PLANNING APPLICATION FORM - CONTINUATION SHEET

QUESTION 6. Condition(s) – Removal

Condition 2

Job No.:	Draw No.:	Stage:	Revision:
031601	PD07	Planning	P2

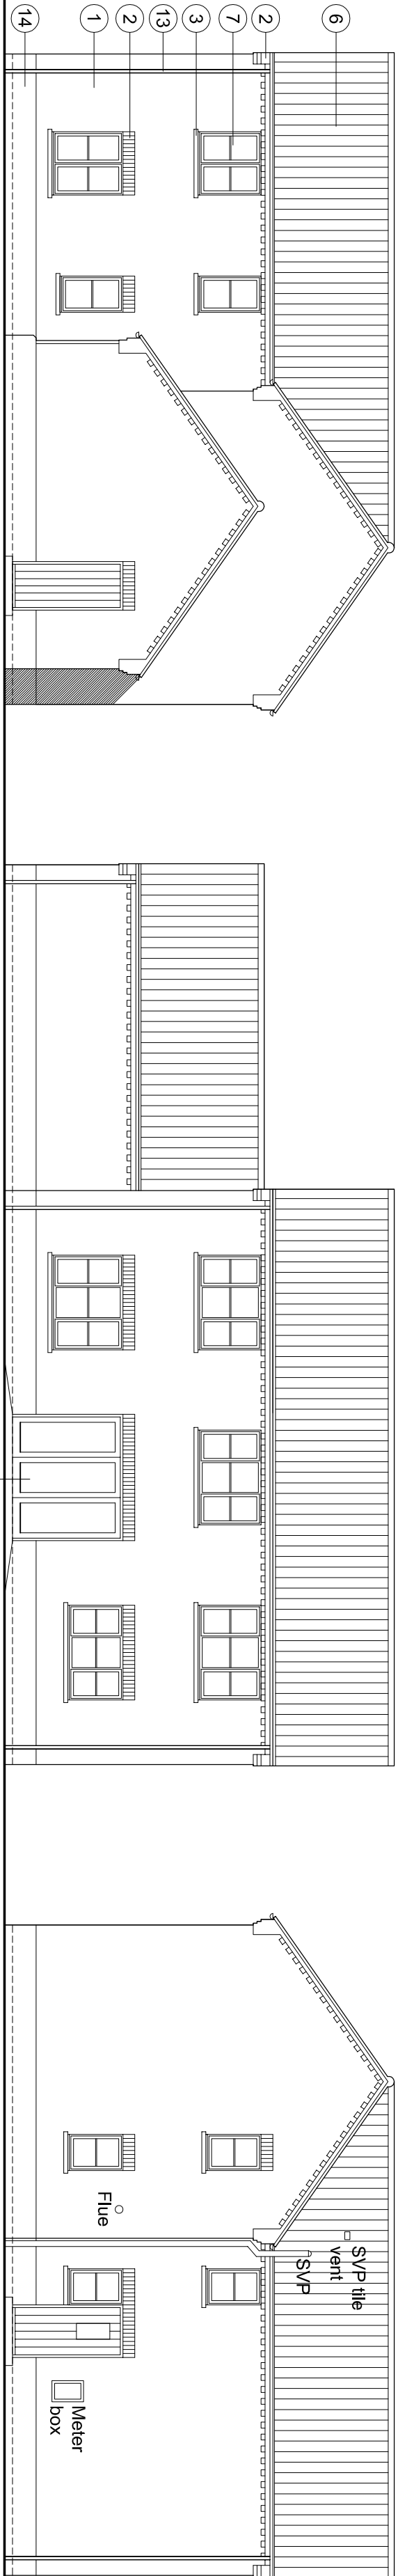
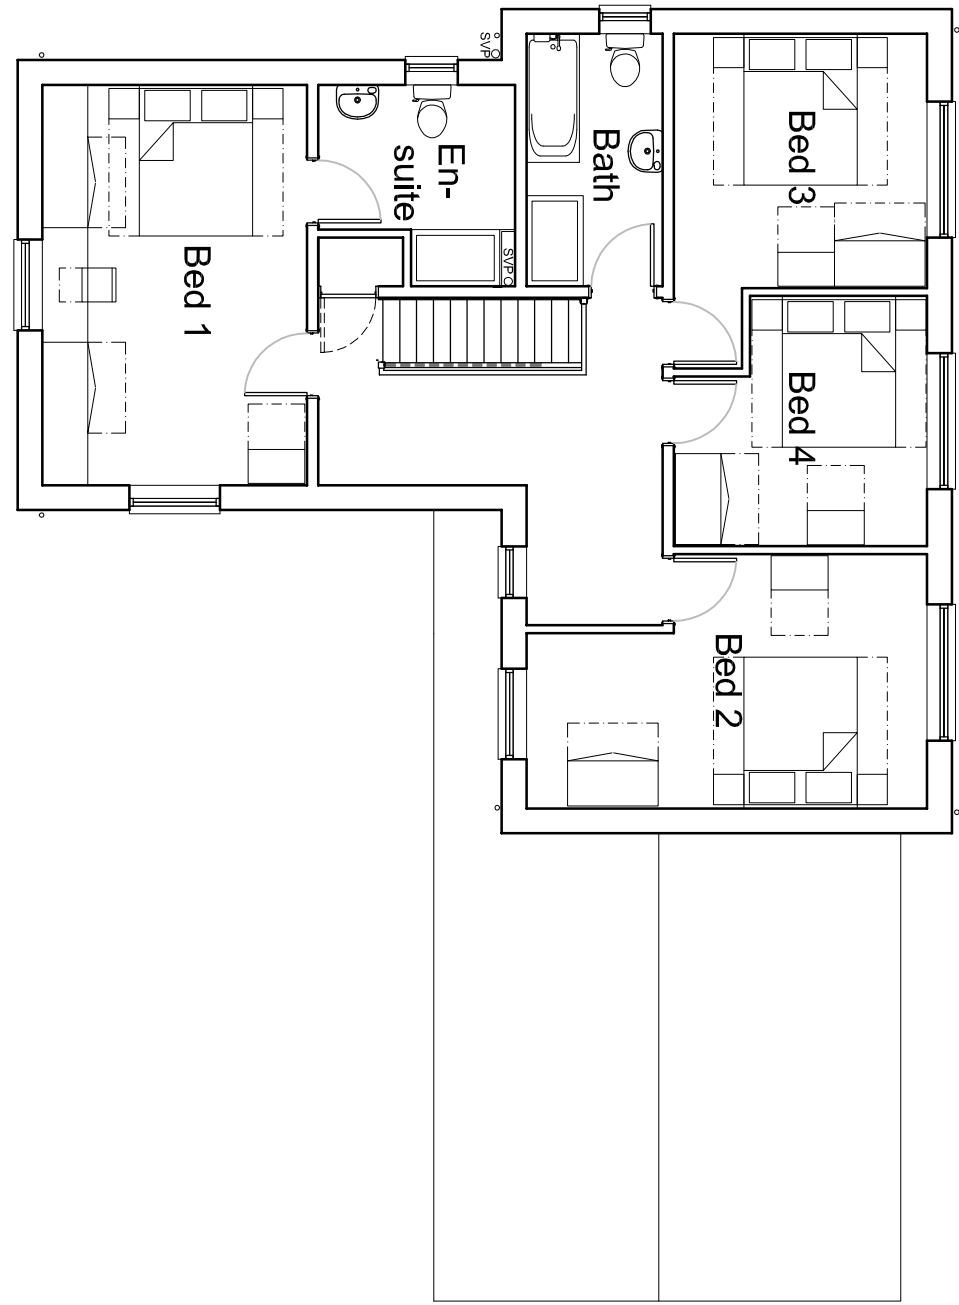
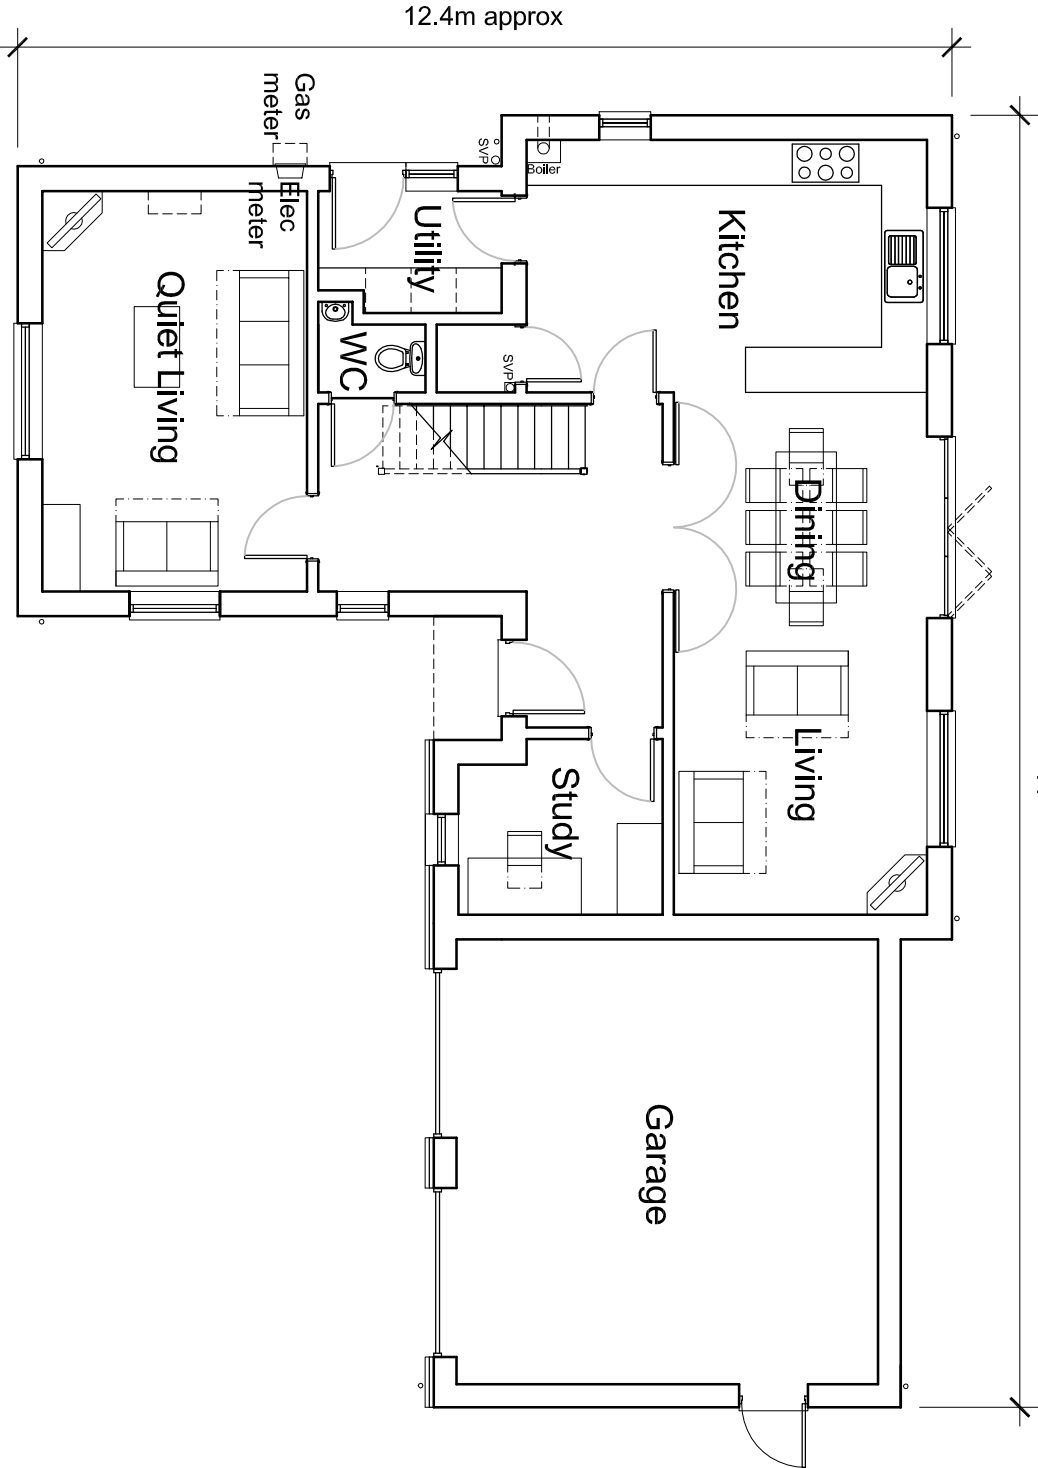
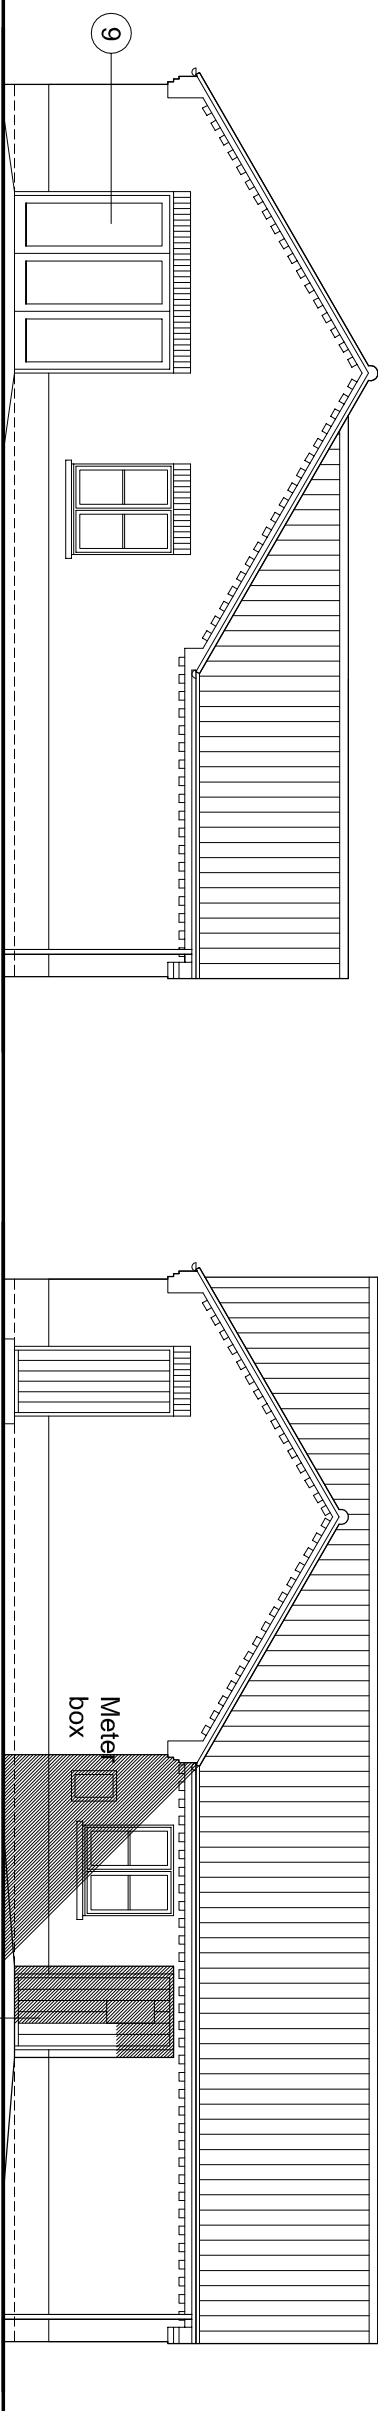
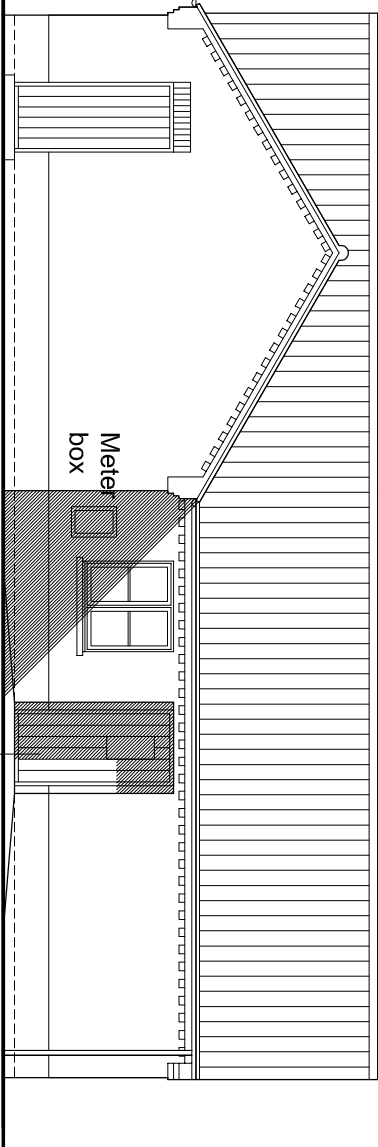
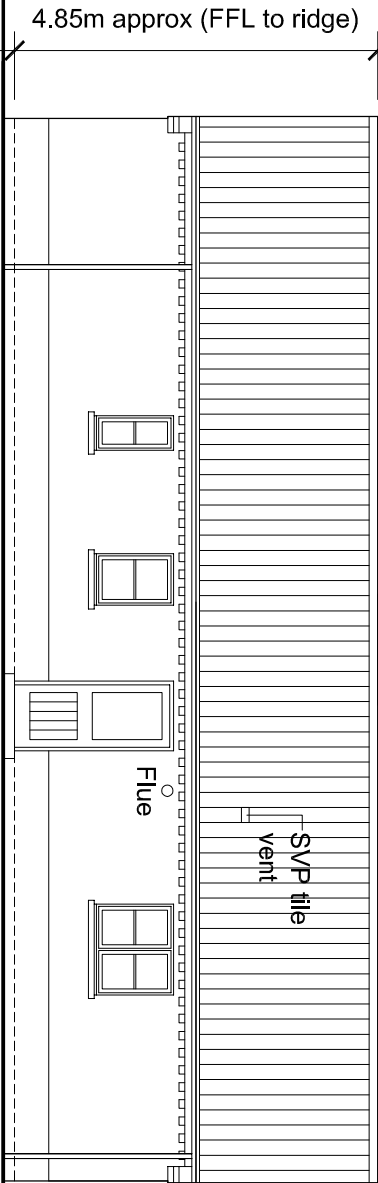
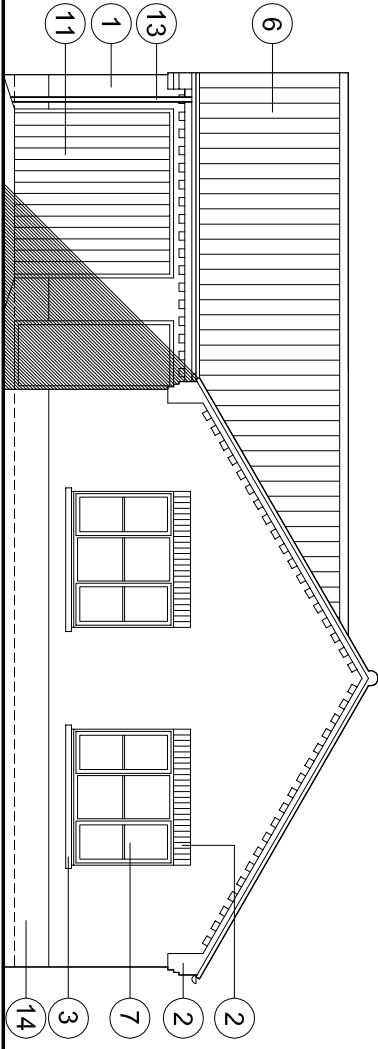
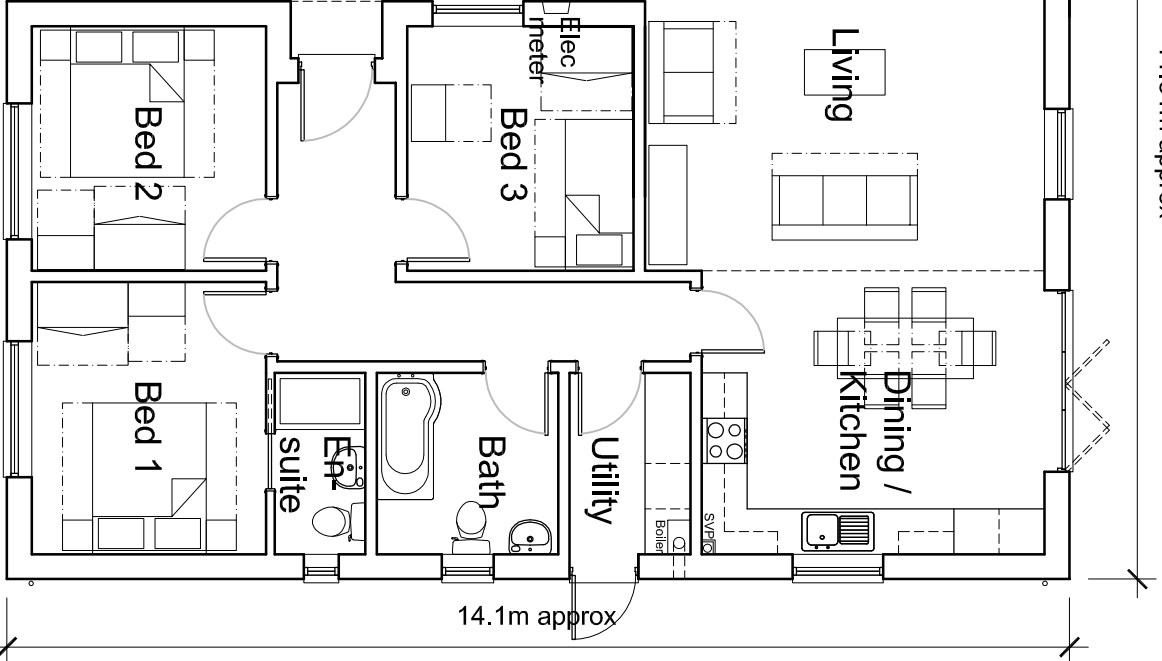
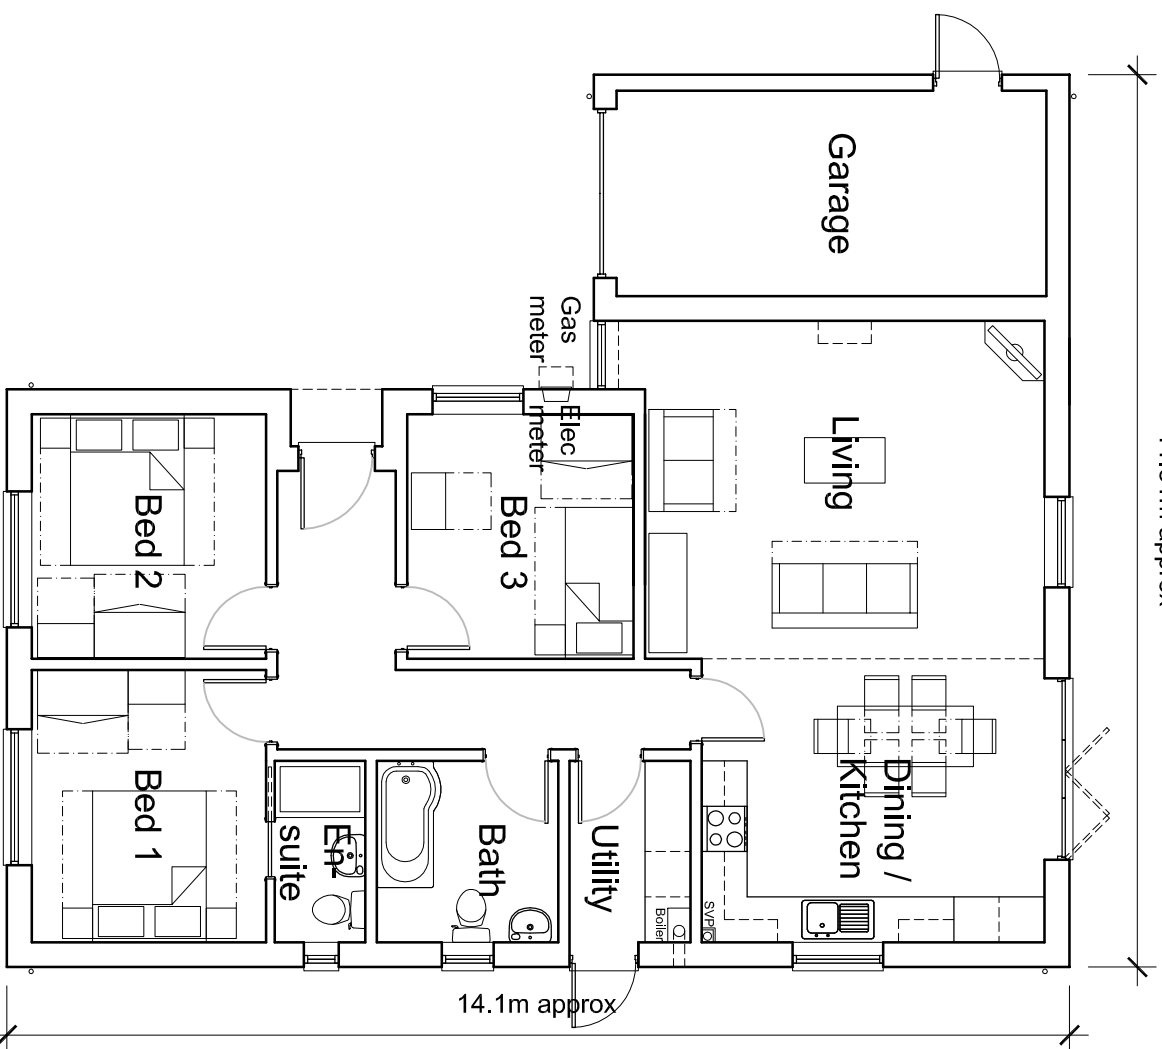
Plot 9 boundary altered.

PD06, PD07, PD08, PD09, PD10 & PD11 are changed to show the addition of meter boxes, gas flues and soil vent pipes. In addition drawing PD08 is changed to show widened properties. In addition drawing PD11 is changed to show revision to plot 32 to be same bungalow type as plot 33.
